Maritime &
Coastguard
Agency

Application by Equinor for an Order Granting Development Consent for the Sheringham and Dudgeon Extension Projects.

Examination Timetable – Deadline 5

Examining Authority's Written Questions 3

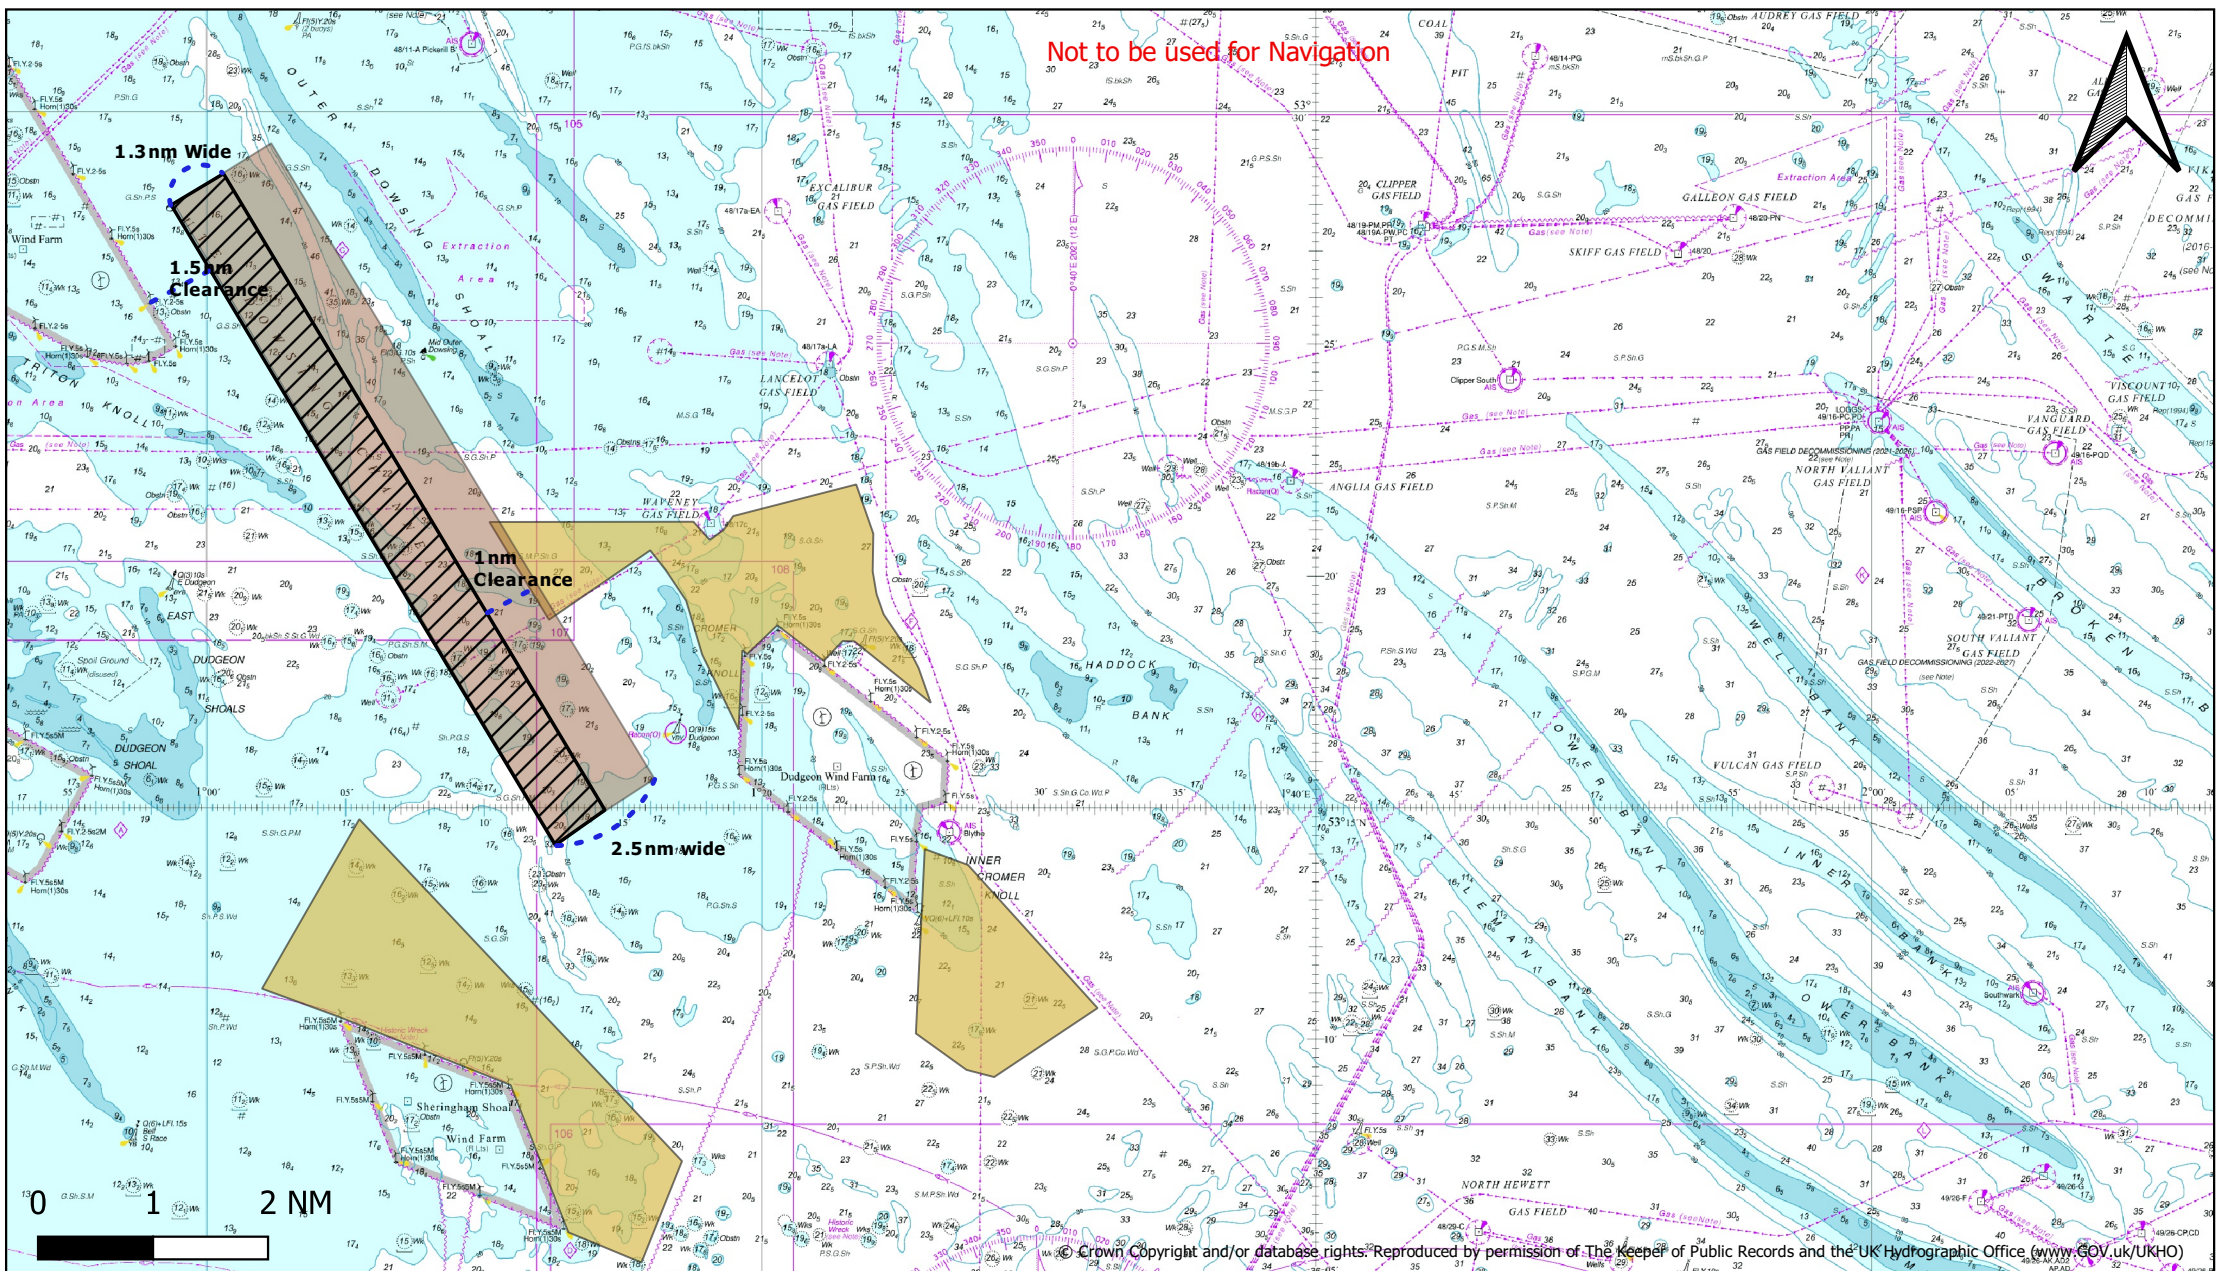
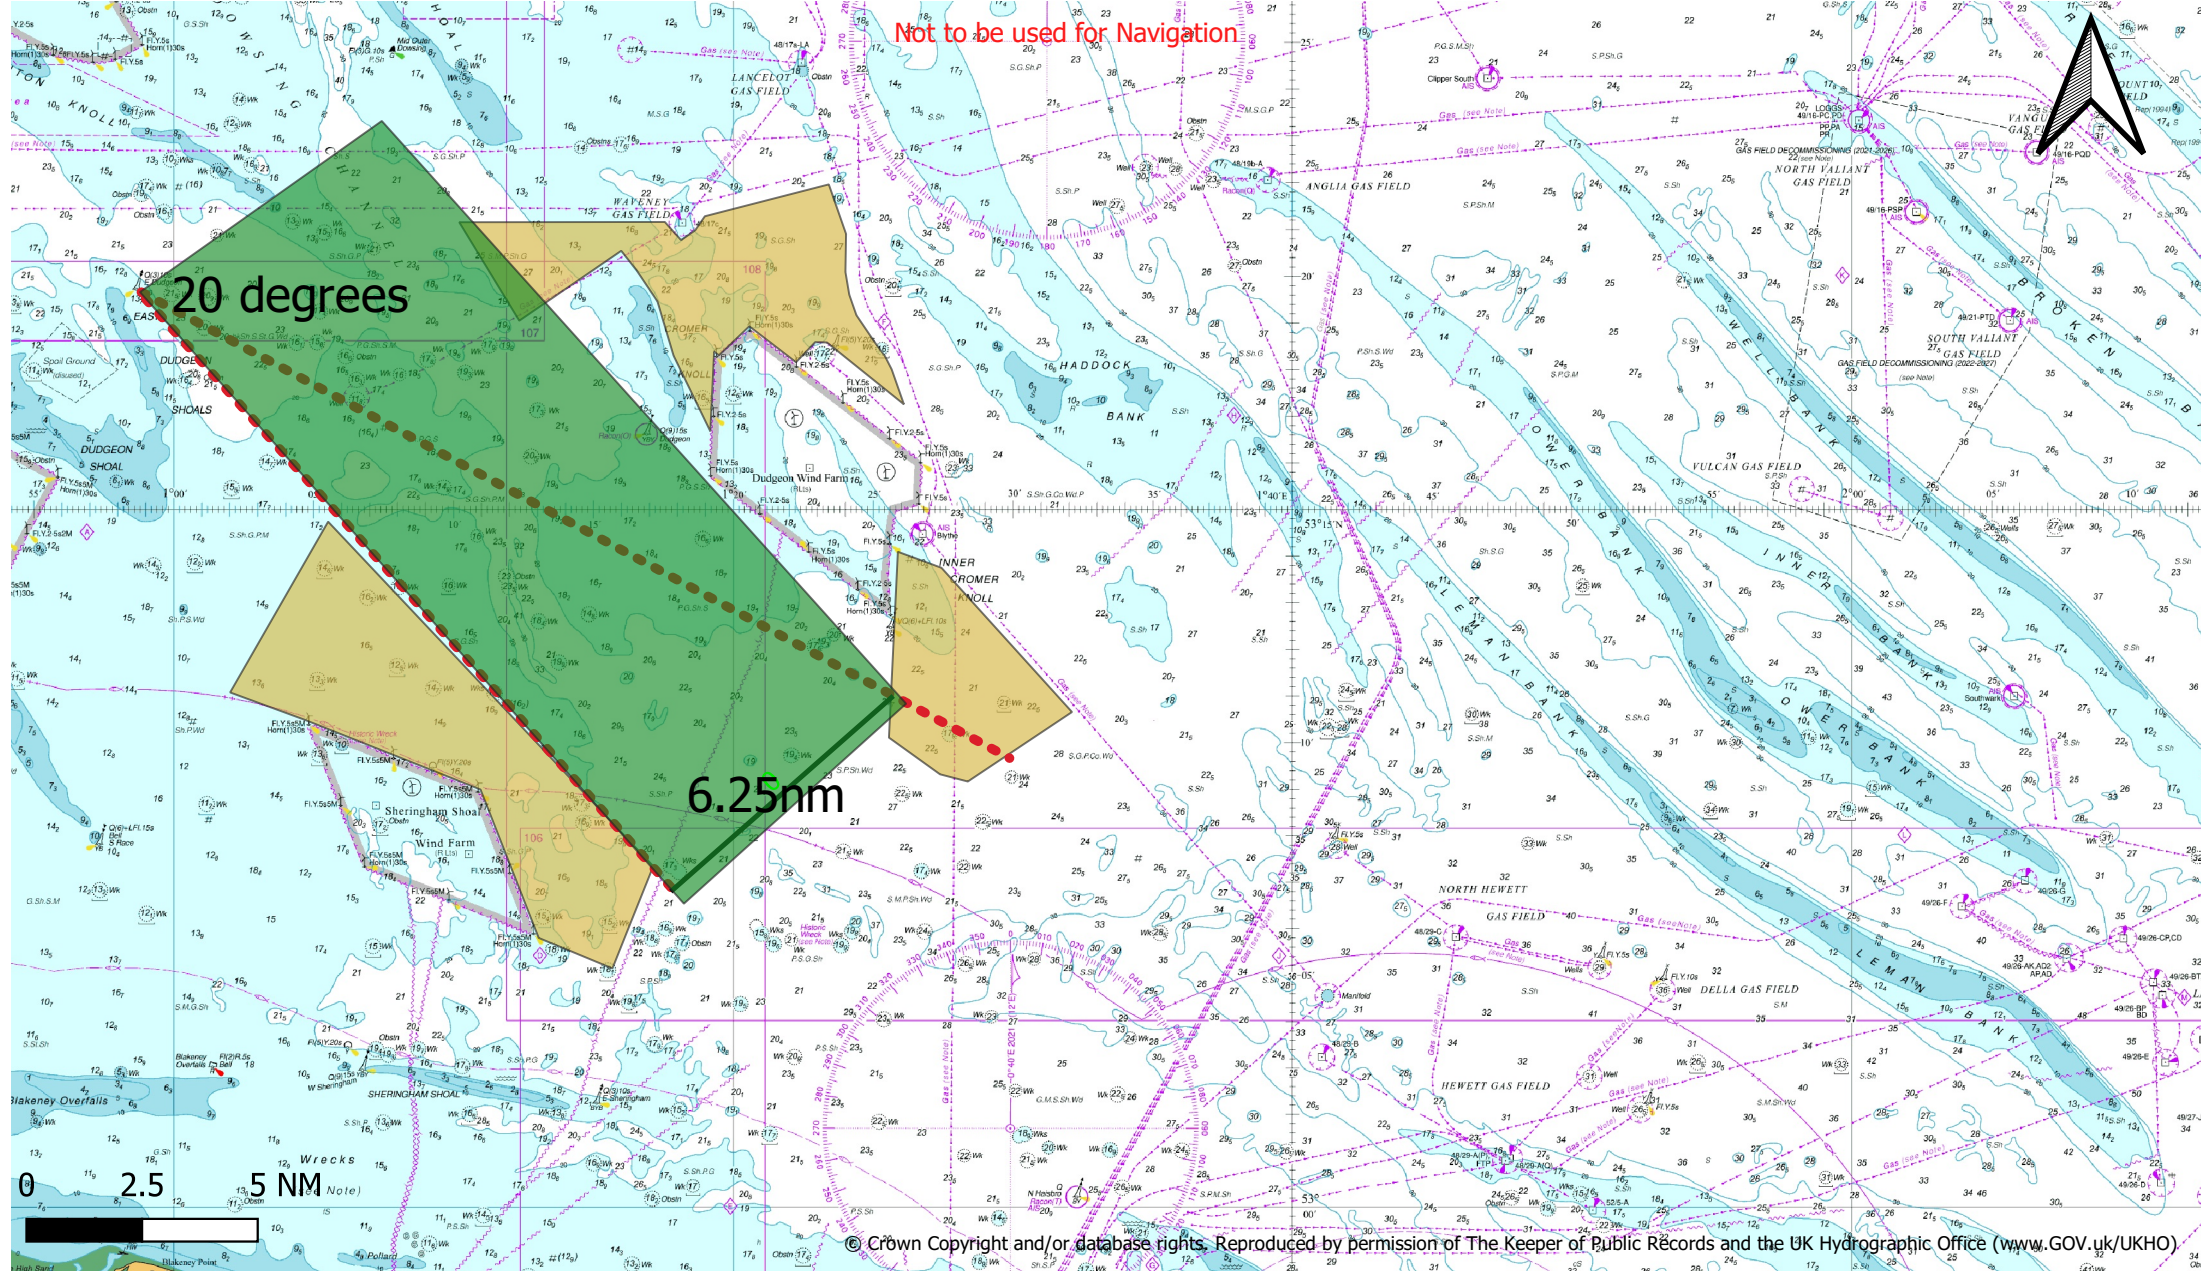
The image below (Figure 1) shows our assessment of the anticipated safe sea room for vessels west of DEP North which includes a 1NM clearance from the boundary:

Figure 1: Safe sea room assessment

MCA's assessment is that the prevailing traffic will also choose to avoid the 15.3m and 13.2m wrecks (controlling depths) southeast of the Triton Knoll Bank. Therefore, the western extent of safe navigable sea space is based on this controlling depth and not the 10m contour line, as shown in Figure 7.2 of the applicant's Navigational Technical Note. This is evidenced in Figure 7.2 which shows all the transits except one, passed east of the 15.3m wreck. Our assessment is that 10m water depth does not provide sufficient depths for vessels with larger draughts in heavier or adverse weather where deeper water is required to accommodate dynamic draught, nor does it allow for the controlling depths as described above.

MCA raised concerns at Deadline 1 in our Written Representation that the area already has high collision risk which would only increase when navigating west of the DEP North array. When a safety buffer of 1NM is applied to the DEP North boundary, our assessment is that vessels will be constricted into a channel 1.3NM wide. This is a reduction of 58% from the current navigable sea room. It should be noted that this only applies to the operational phase. During the construction phase construction buoys will be deployed and the available sea room will be less than 1.3NM. An estimation of the sea room in this instance will not be possible until the positions of the construction buoys are known.

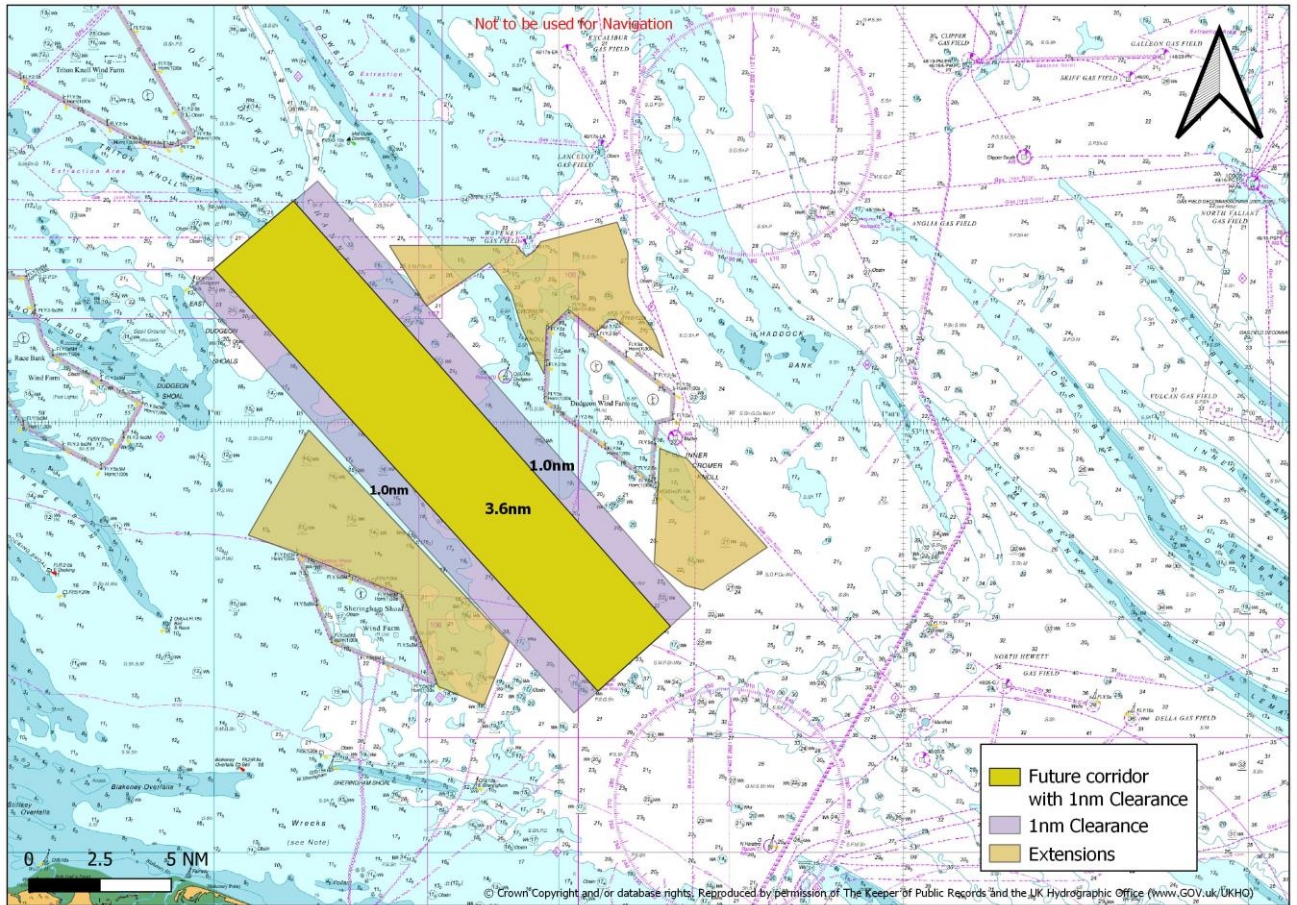
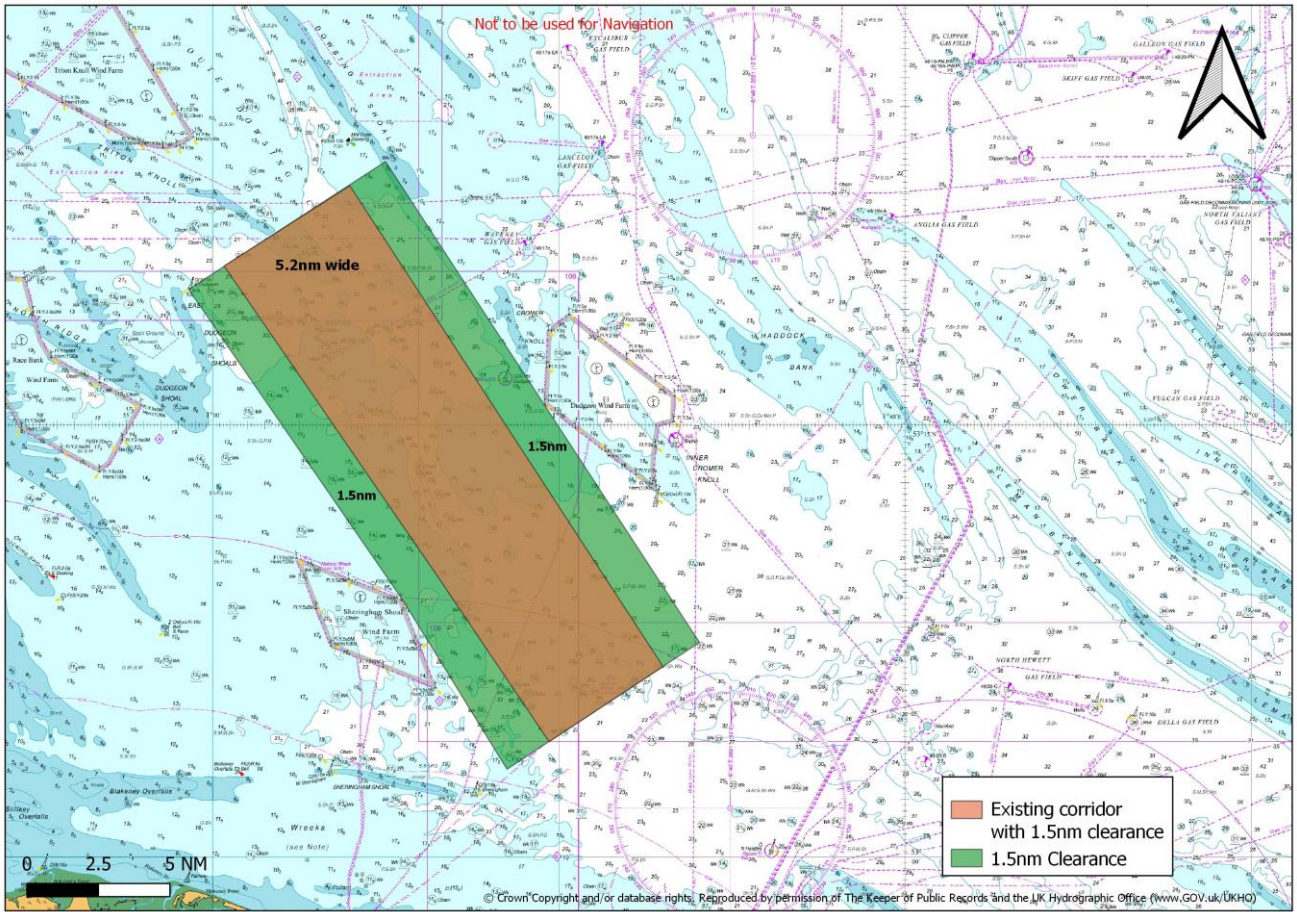
The image below (Figure 2) shows a line running through the Mid-Outer Dowsing buoy and Dudgeon buoy and MCA recommends the boundary is reduced to this line, as a minimum:

Figure 2: Recommended boundary amendment

There would still be a reduction of safe navigable sea room to the current availability when safety clearances are implemented. Figure 2 shows the current extent of traffic (magenta line), and the distance between this shipping route and the amended turbine boundary would be 0.5NM which is the minimum recommended distance in MCA guidance MGN654 Annex 2 'Wind Farm Shipping Route Template'. This reduced boundary would increase the safe navigable sea room to 2.2NM when a 1NM clearance distance is applied.
